2024/0739

4 Upper Sheffield Road, Barnsley, S70 4PL

Demolition of outbuilding and garage and formation of new driveway, retaining walls, railings and gates and associated fence, and alterations to existing dropped kerb.

TITLE  
Proposed Site Sections (4.1m Wide Drive)

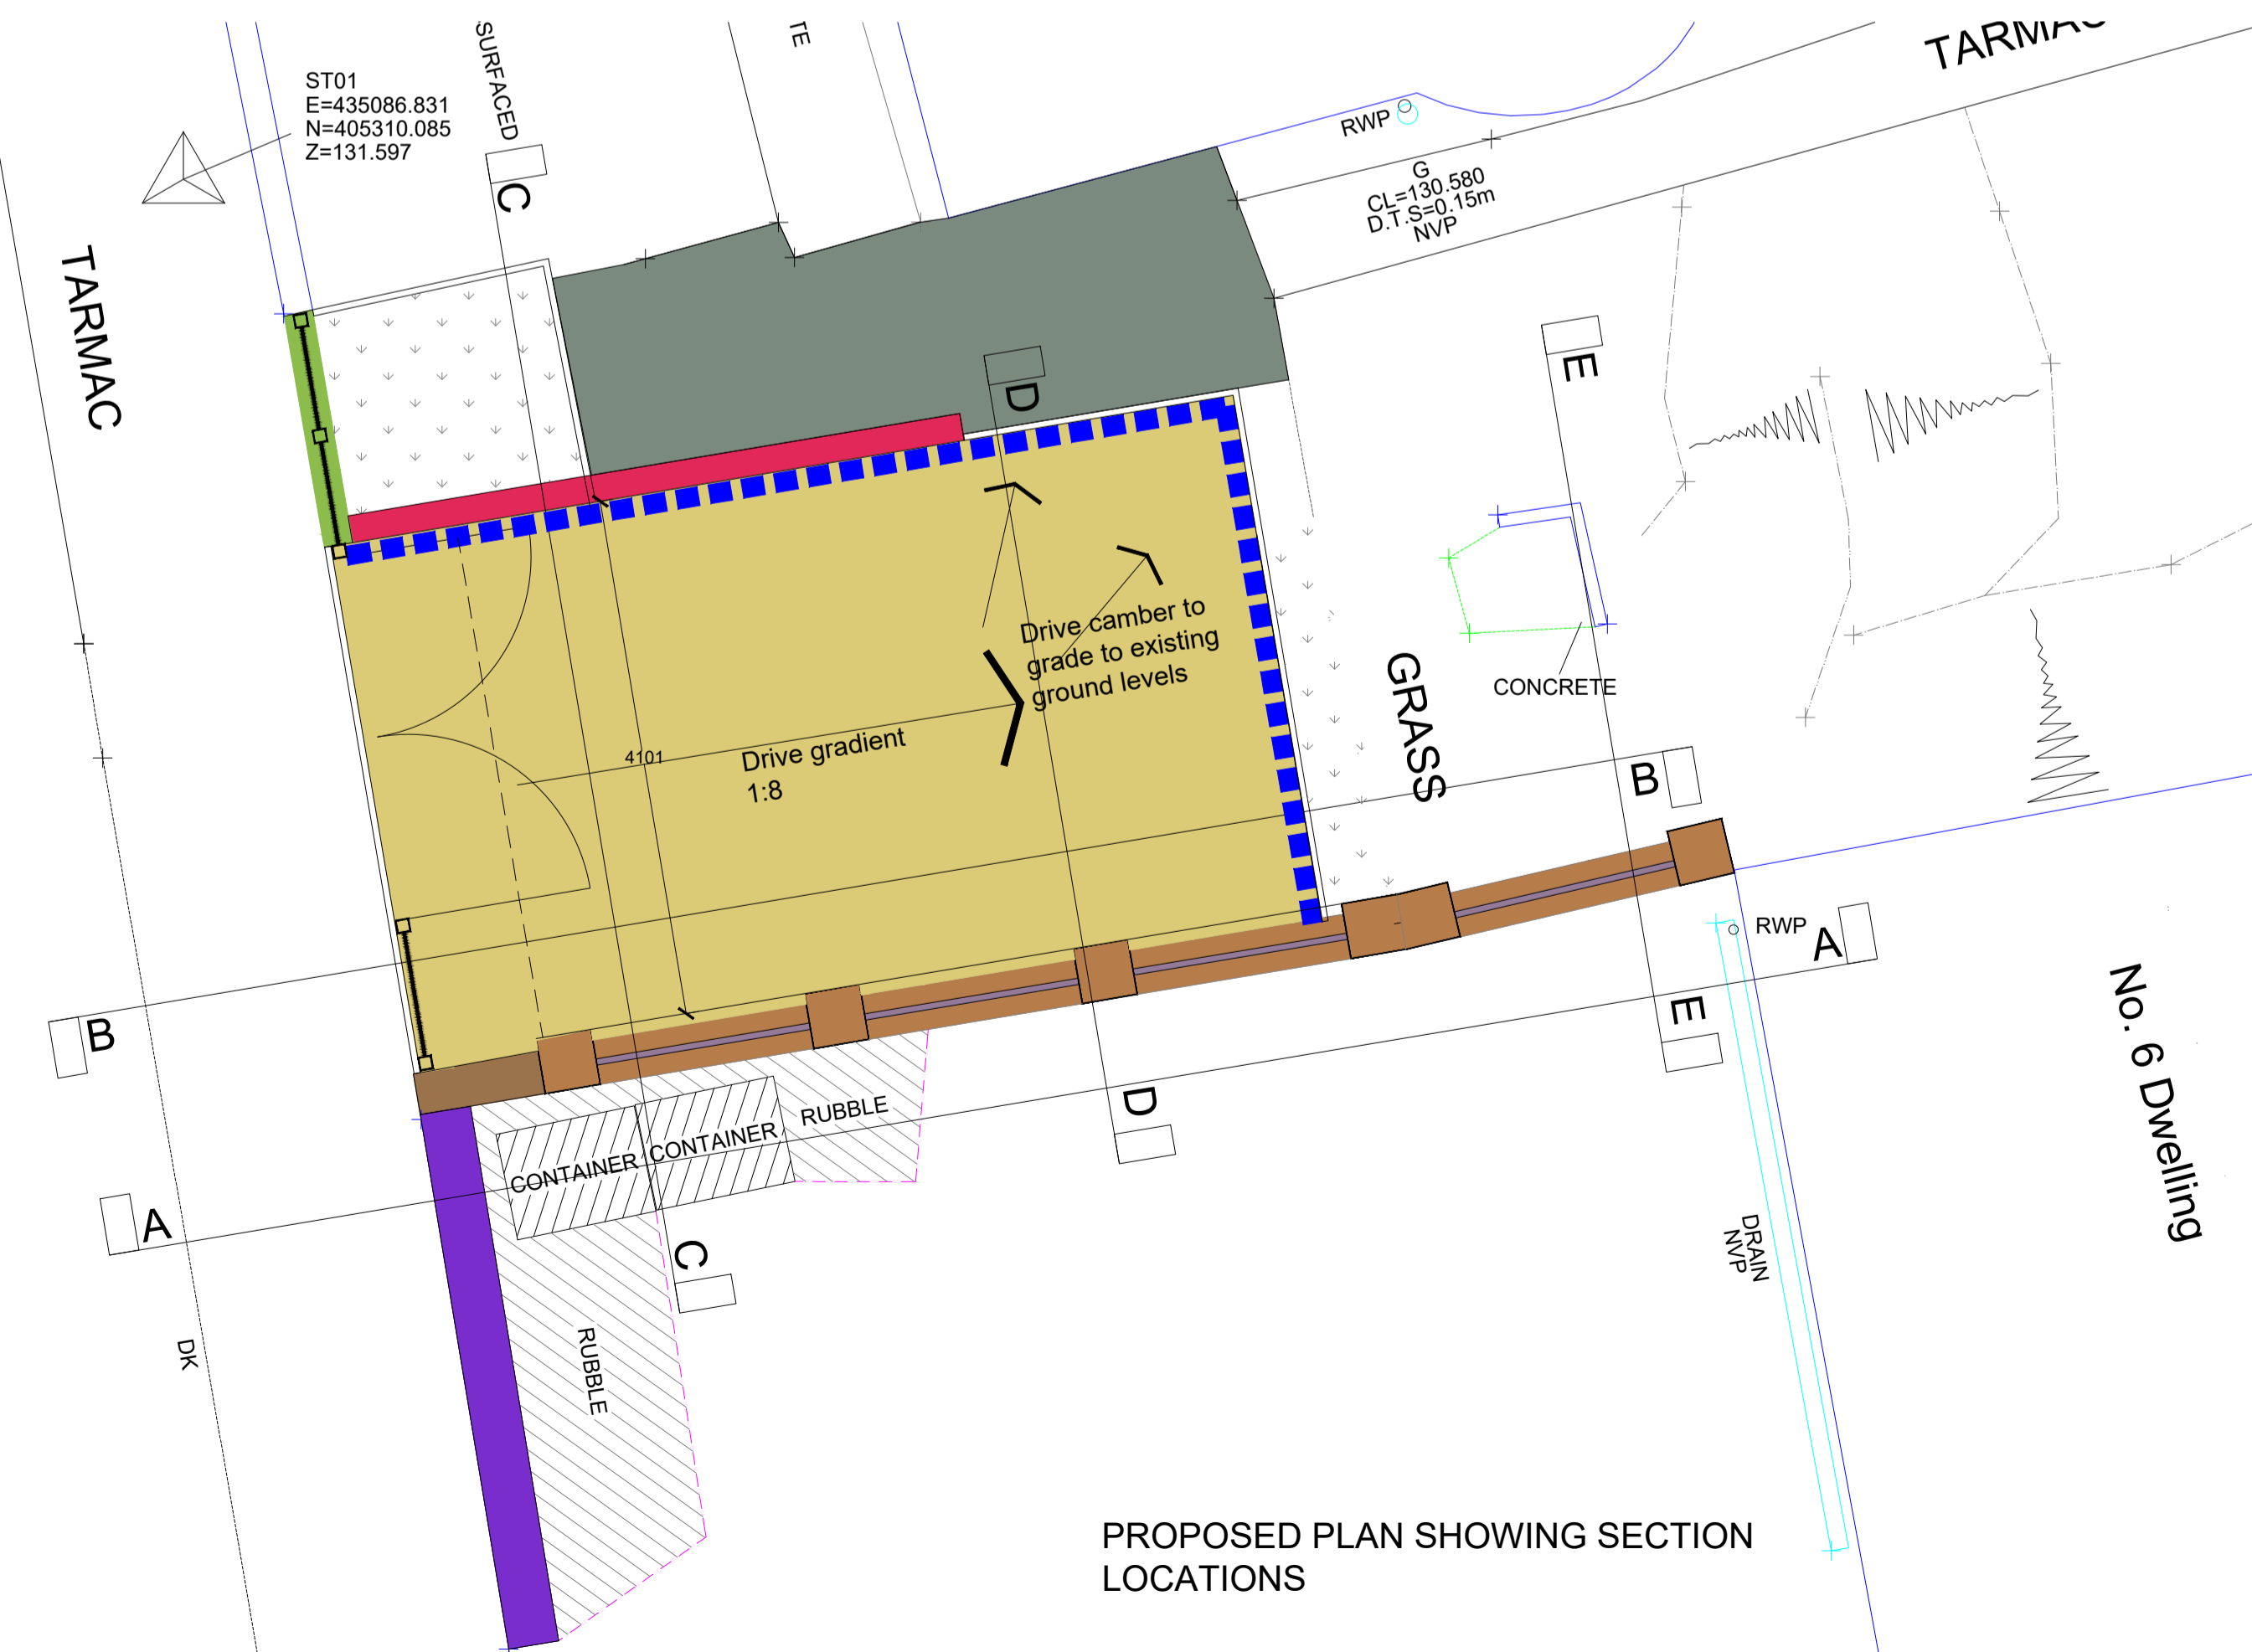
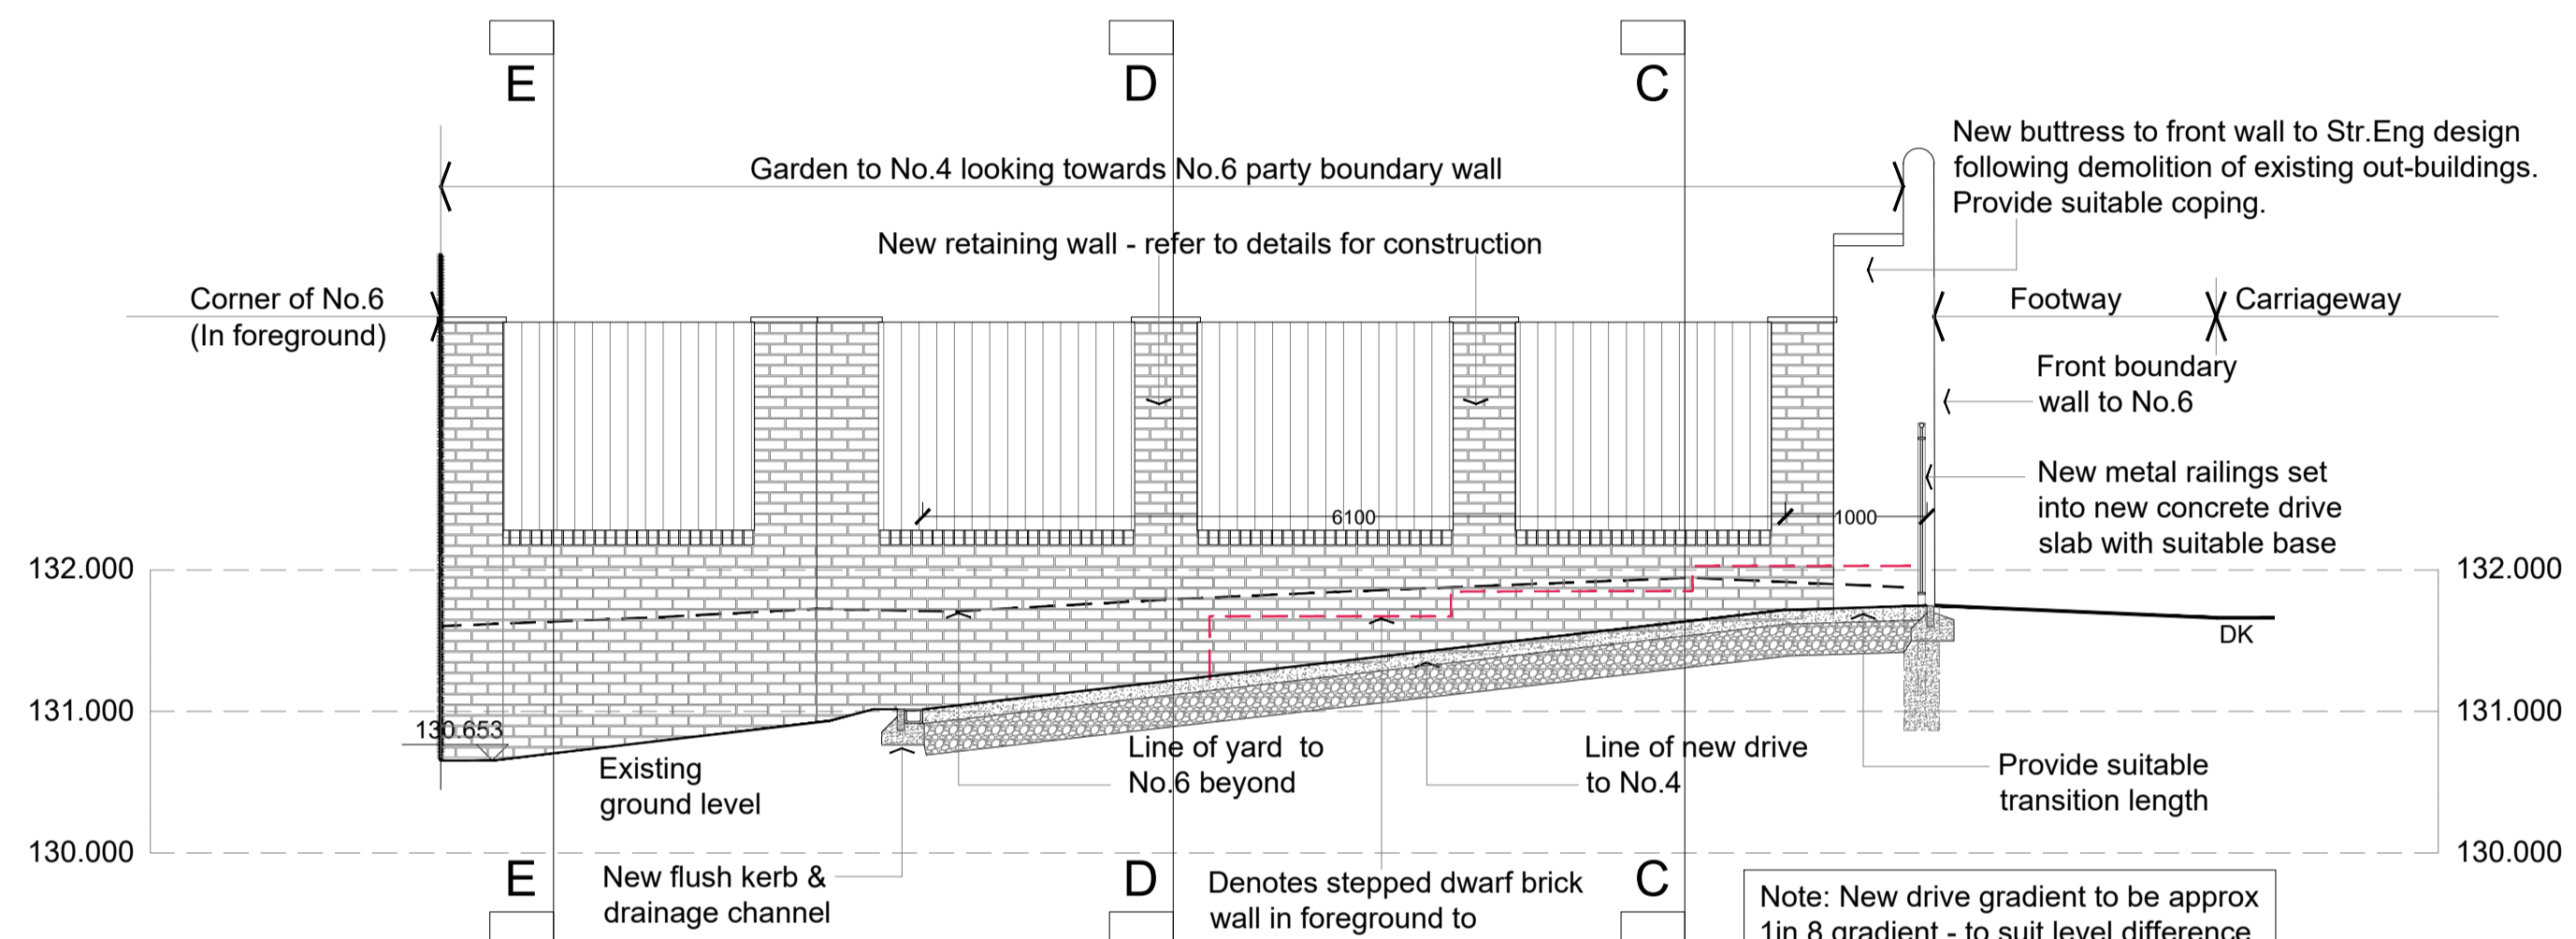
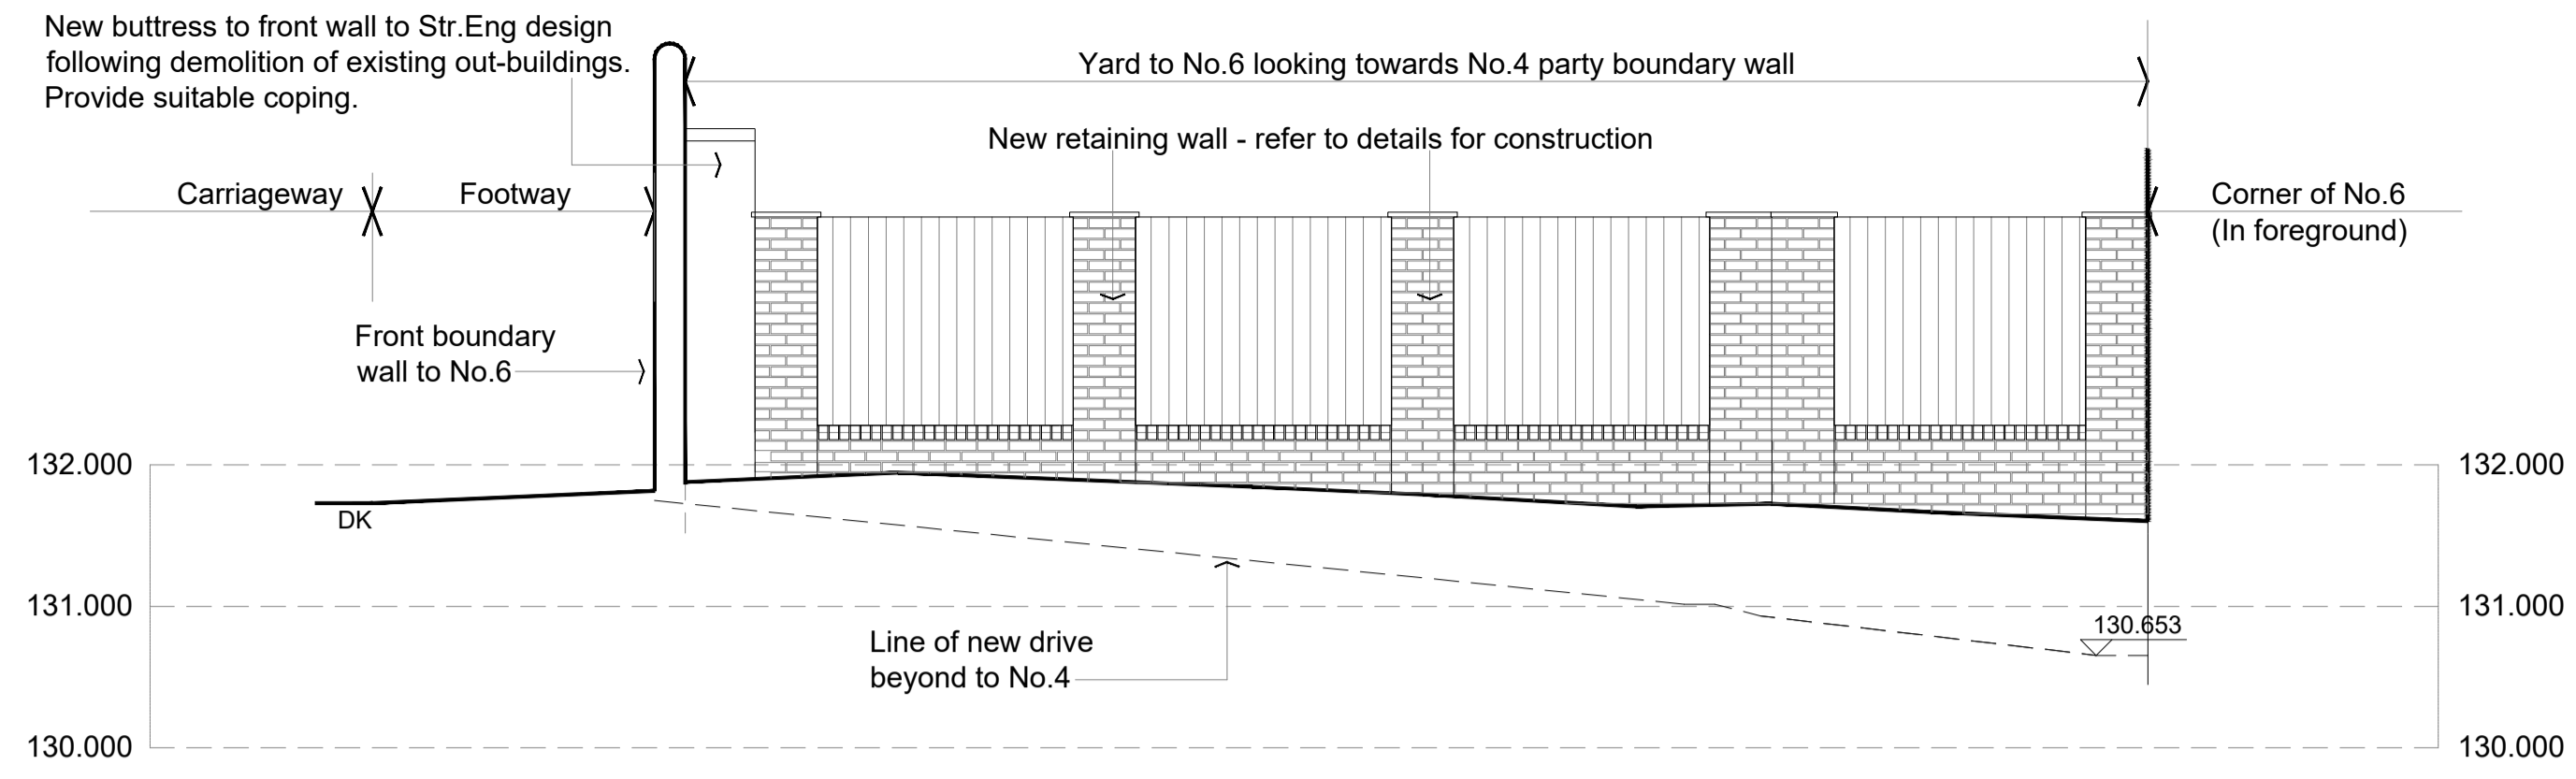
Highways DC – Objects to the proposed gradient of the driveway.

During the application process, Highways DC objected to the proposal on the basis that the proposed 1:8 gradient of the driveway would not be acceptable, and in the interests of the safety of the users of the public highway and those using the access, the maximum permitted gradient would be 1:12. These comments were relayed to the agent. In response to the comments, the agent stated that they understood the 1:12 gradient to be taken from the SYRDG in relation to new build and explained that they are constrained in this instance by tying into the existing levels of the site. Moreover, the Technical Manager of BMBC Highways and Transportation whose role involves overseeing the installation of vehicular crossings had been consulted and raised no concerns. It was also stated that a transition length at the start of the drive has been proposed to reduce the impact of the 1:8 gradient for the remainder of the drive, and that they would like to maintain the existing footpath levels and not have to introduce any steps between the new drive and the existing footpath serving the property and giving access to the adopted footway. This response was relayed to Highways DC. In response, Highways DC stated that the maximum 1:12 gradient as stated in the SYRDG relates to all new development and that the creation or alteration of a vehicular access or driveway constitutes new development and is therefore bound by the technical requirements set out in the SYRDG. It was also stated that Mount Vernon Road is a classified road (C595), and that classified roads by their very nature are busier roads and it is considered that vehicles reversing to/from a driveway of an excessive gradient could potentially have a detrimental impact in terms of highway safety for oncoming vehicles and pedestrians. Highways DC maintained their initial objection.

On balance, the proposal is therefore considered to maintain highway safety to a reasonable degree and would be acceptable. The driveway would provide a sufficiently sized off-street parking space replacing an existing detached garage which Highways DC have stated as being of a substandard size. The proposed gates would open into the site replacing an existing garage door which Highways DC have stated that when opened would encroach into the public highway. The proposed western boundary treatments would replace existing high stone walls with low built brickwork walls and would likely result in improved visibility. While the gradient of the driveway would not comply with the technical requirements as set out in the SYRDG, the driveway would tie into existing site levels and could be implemented as permitted development. It is therefore considered that the anticipated benefits of the proposed scheme would outweigh any potential harm that could occur because of the gradient of the driveway.
